**Consultation Response from KC,
Highways Development Management****2025/91638 The Mansion House, Heaton Lodge, Bog Green Lane, Colne Bridge, Huddersfield,
HD5 0RF****Outline application for erection of residential development (3 dwellings)****Date Responded: 2 July 2026****Responding Officer: Sheila Henley****Responding Ref: 4-15SE/4****Recommendation: No objection subject to condition.**

Plan ref: 10c - site & location plans.

Reconsultation, on a reduction in the number of dwellings from five to three with all matters reserved. It is noted that the application form and the design and access statement state five dwellings, three dwellings form the basis of the review.

Site plan (1:500)

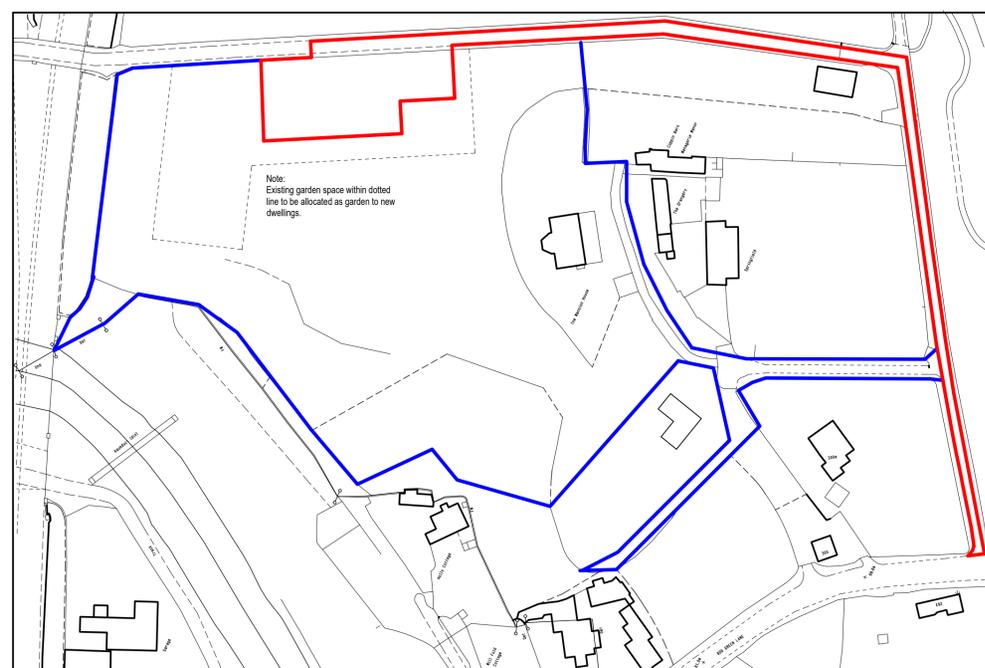
Access is to be gained from an unadopted shared surface private lane from the B6118, Bog Green Lane and is expected to form a private drive with turning point and to lead to the three plots where each would have hardstanding for pedestrian and vehicle parking. The private drive junction will require to have provision of sight lines in each direction at c2.4m x 17m.

Internally, details of a swept path for a fire and rescue appliance will be necessary to confirm the circulation and forward gear entry and exit of the private drive.

No details are provided of the exterior plot layout. It is likely that hardstanding will be necessary for pedestrian access and the parking and turning of vehicles and this should be sized to cater for pedestrian needs and to meet the amount and size of parking spaces.

It is likely that two spaces per dwelling would be sufficient with at least one visitor parking space within the private drive.

There would be space for bin storage and collection arrangements would need to be confirmed.

Prior to the commencement of the development hereby permitted full details in the form of scaled plans and or written specifications shall be submitted to and approved in writing by the Local Planning Authority to illustrate:

- i. Access arrangements
- ii. Visibility splays
- iii. Site and plot layouts
- iv. Parking provisions for cars, cycles, evcp's
- v. Turning areas
- vi. Surfacing
- vii. Surface water drainage, if relevant
- viii. Bin storage and collection arrangements
- ix. Swept path analysis
